BOTLEY WEST SOLAR FARM

OXFORDSHIRE HOST AUTHORITIES RESPONSES FOR DEADLINE 3 | TUESDAY 22 JULY 2025

RESPONSES FOR DEADLINE 3

- Order Limits:
- Cable Corridor:
- Cable Corridor Option:
- Indicative HDD Entry / Exit Pit:

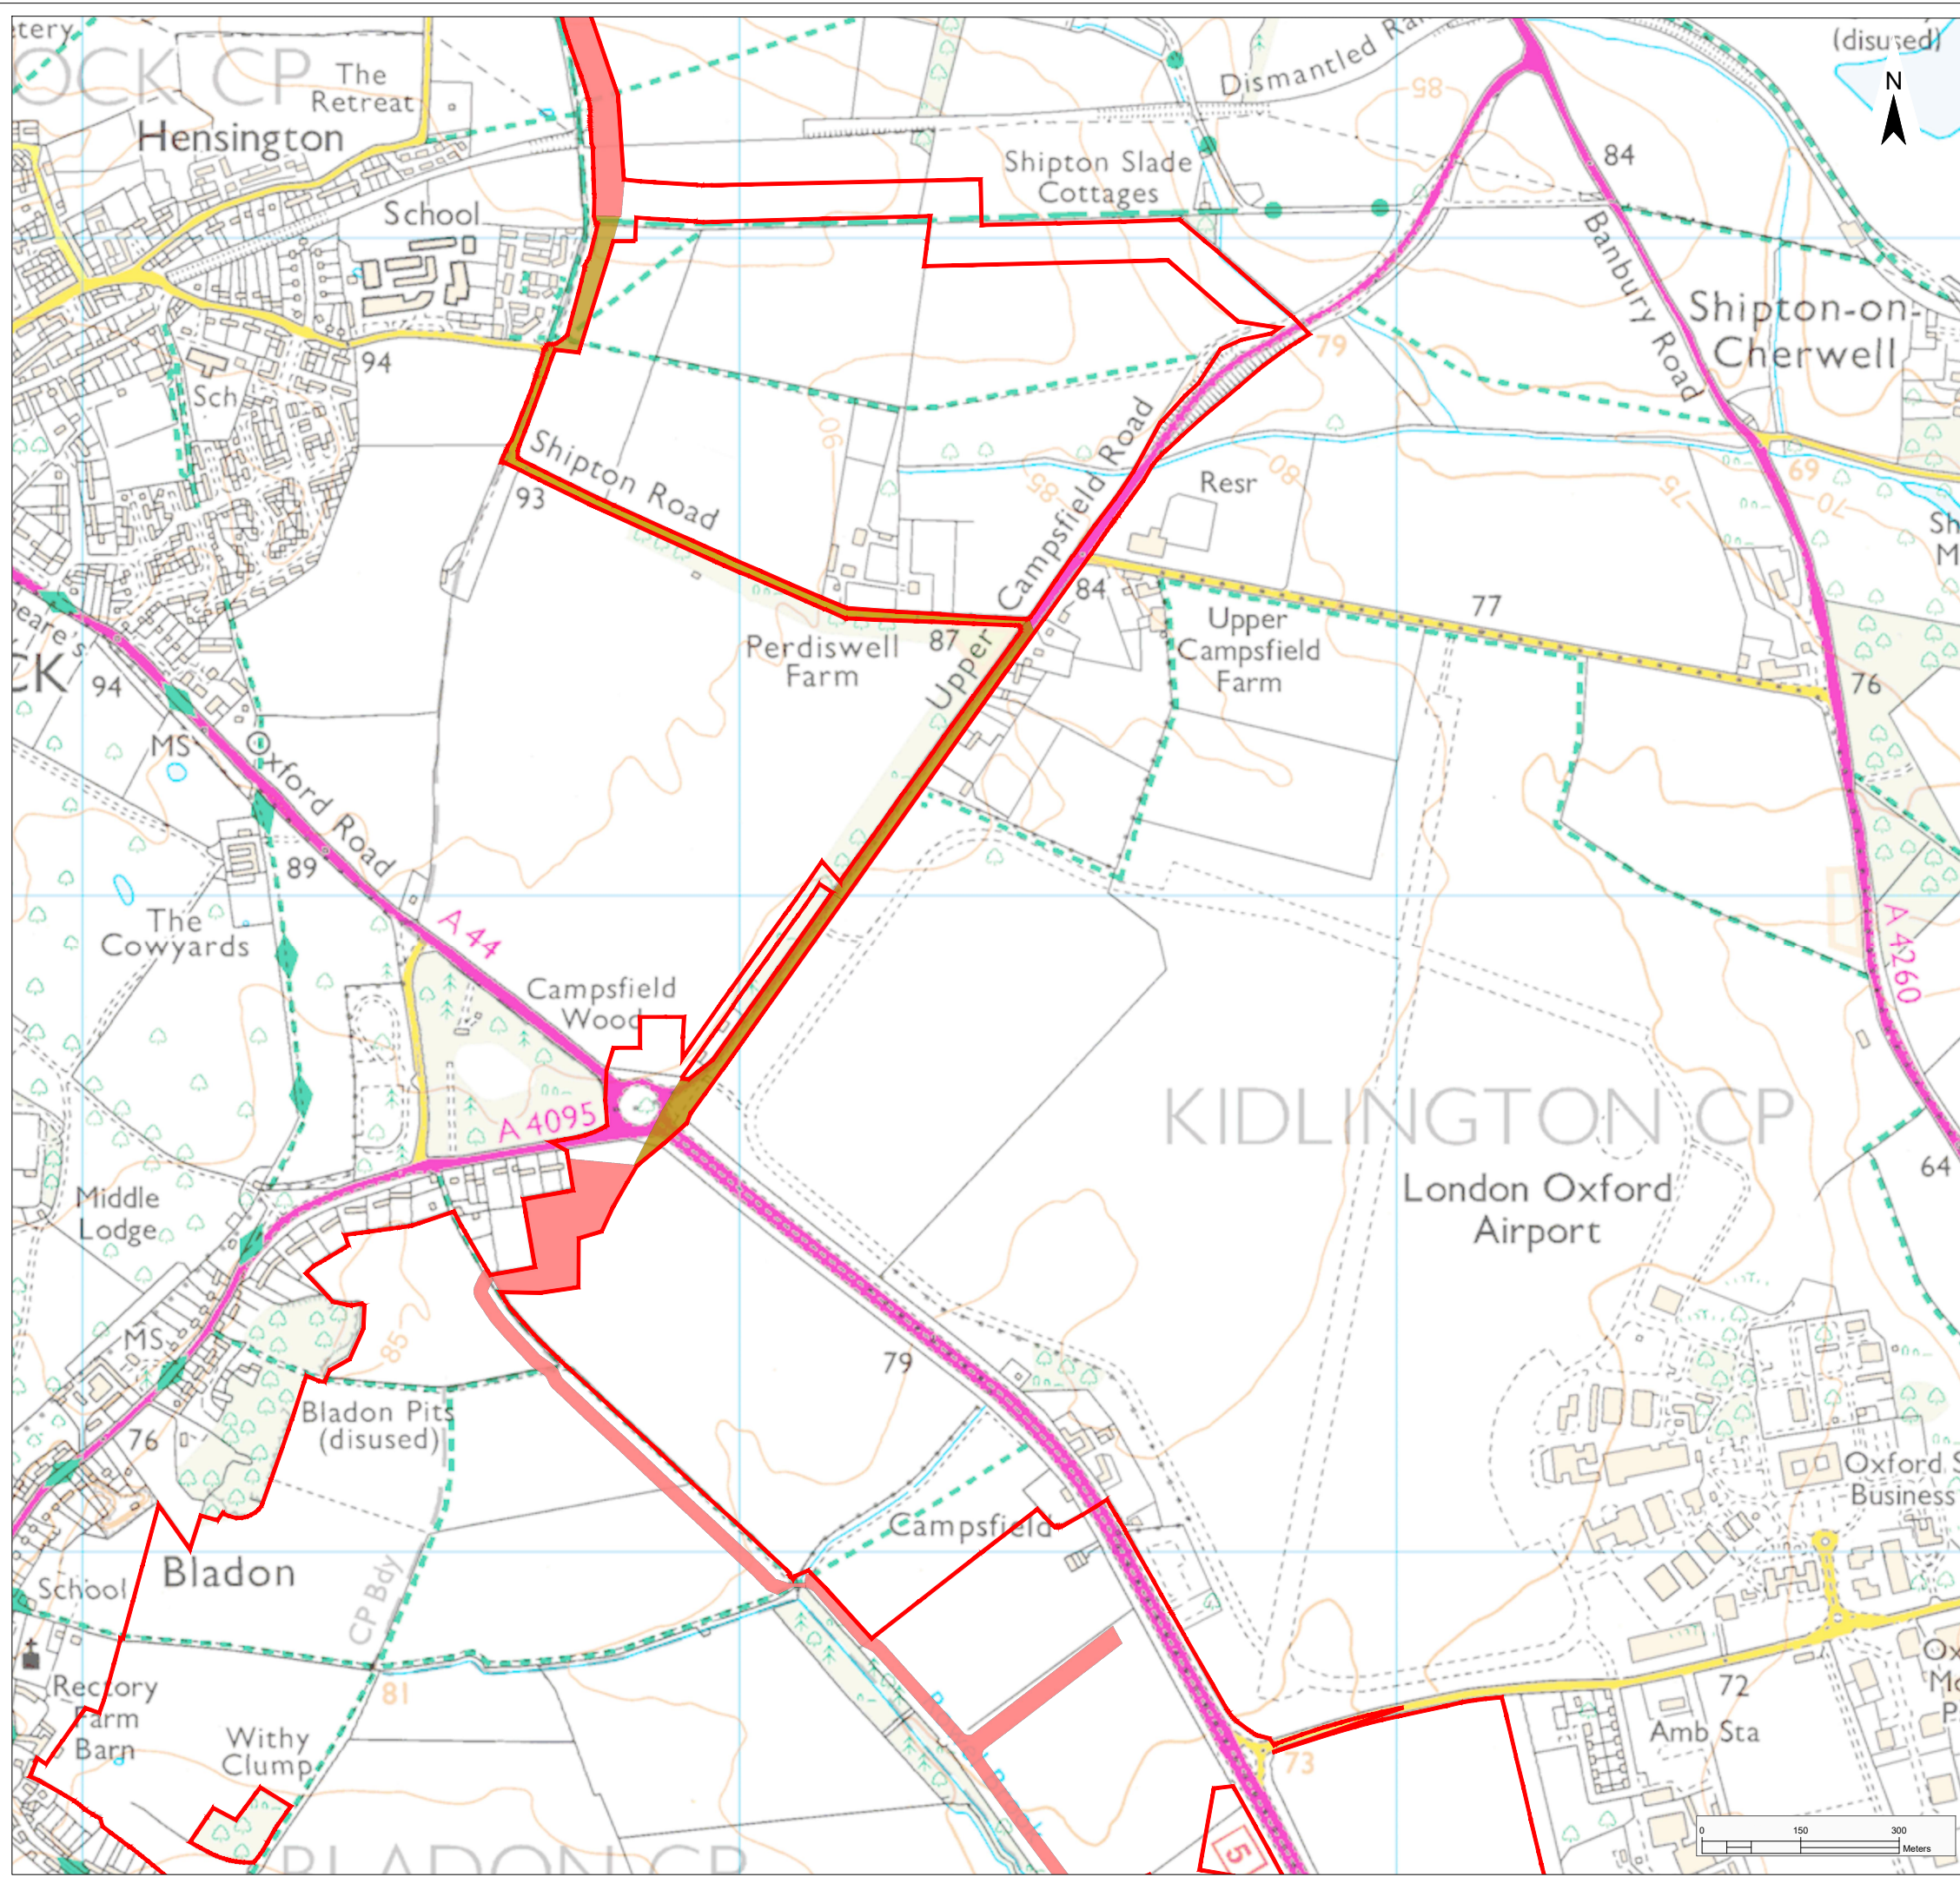
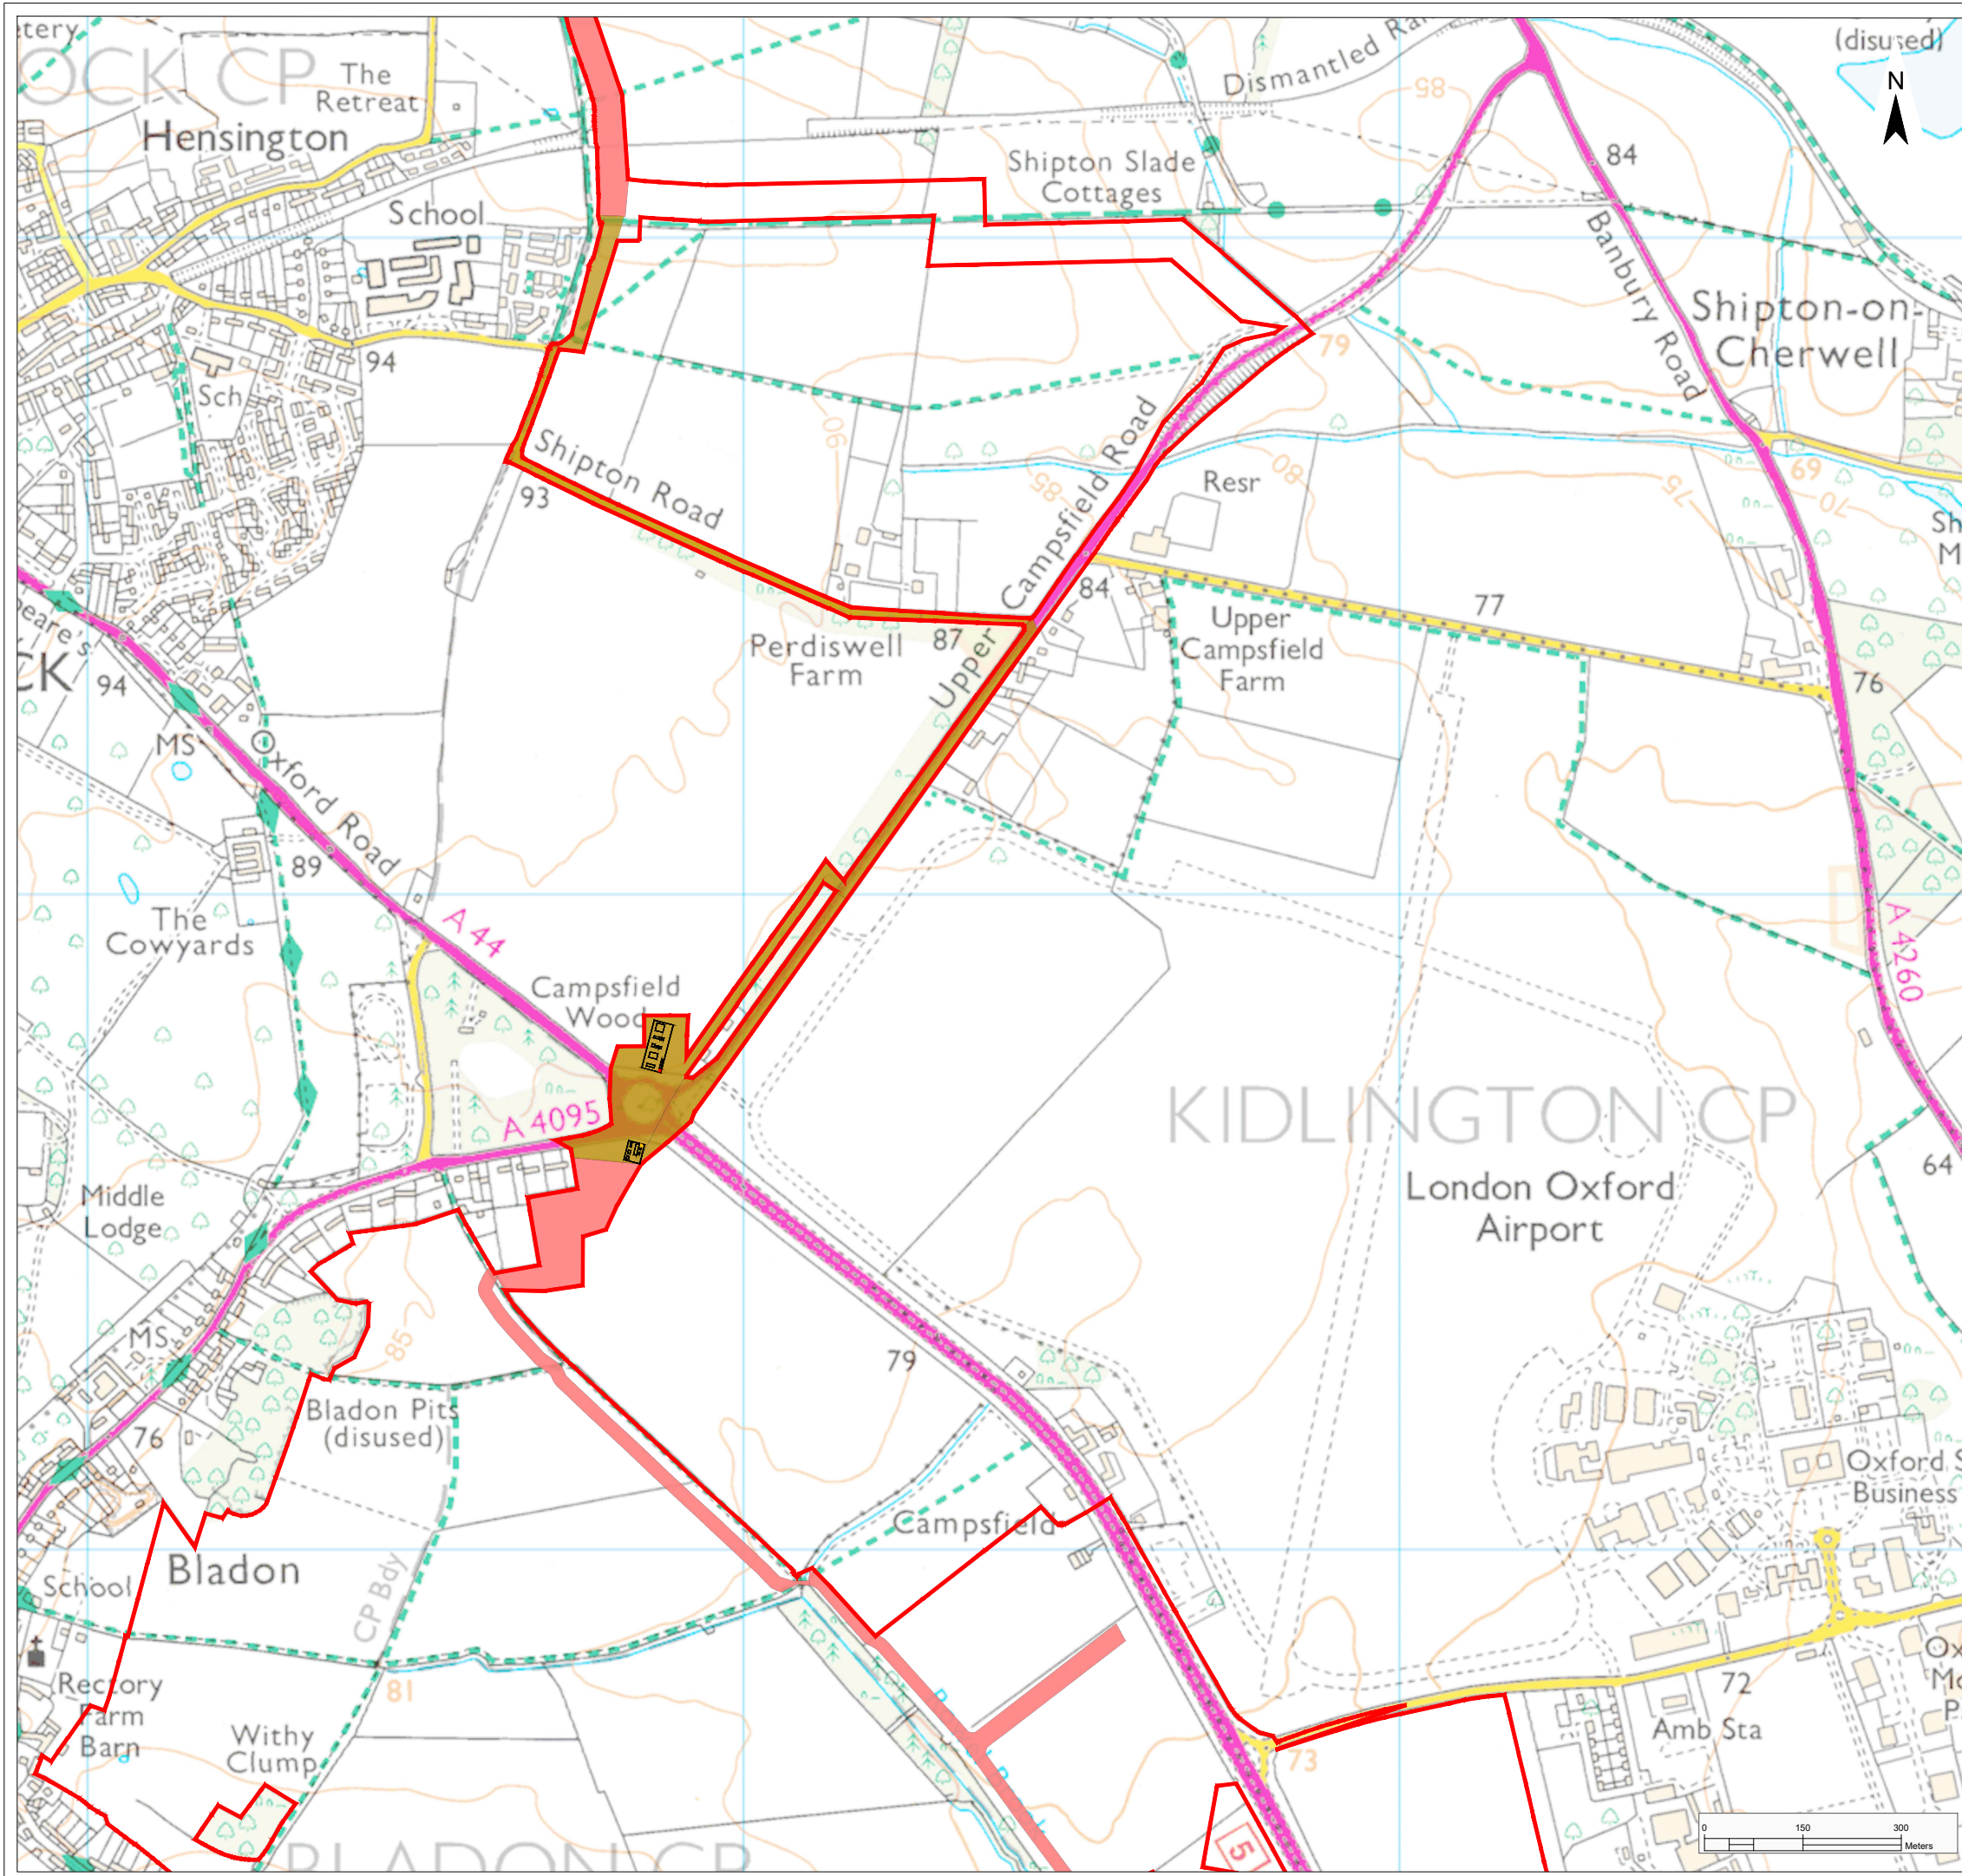
The Illustrative Masterplan suggests that such planting is currently not proposed, and the OHA requests that this is secured as part of the DCO process in liaison with the CNLB.
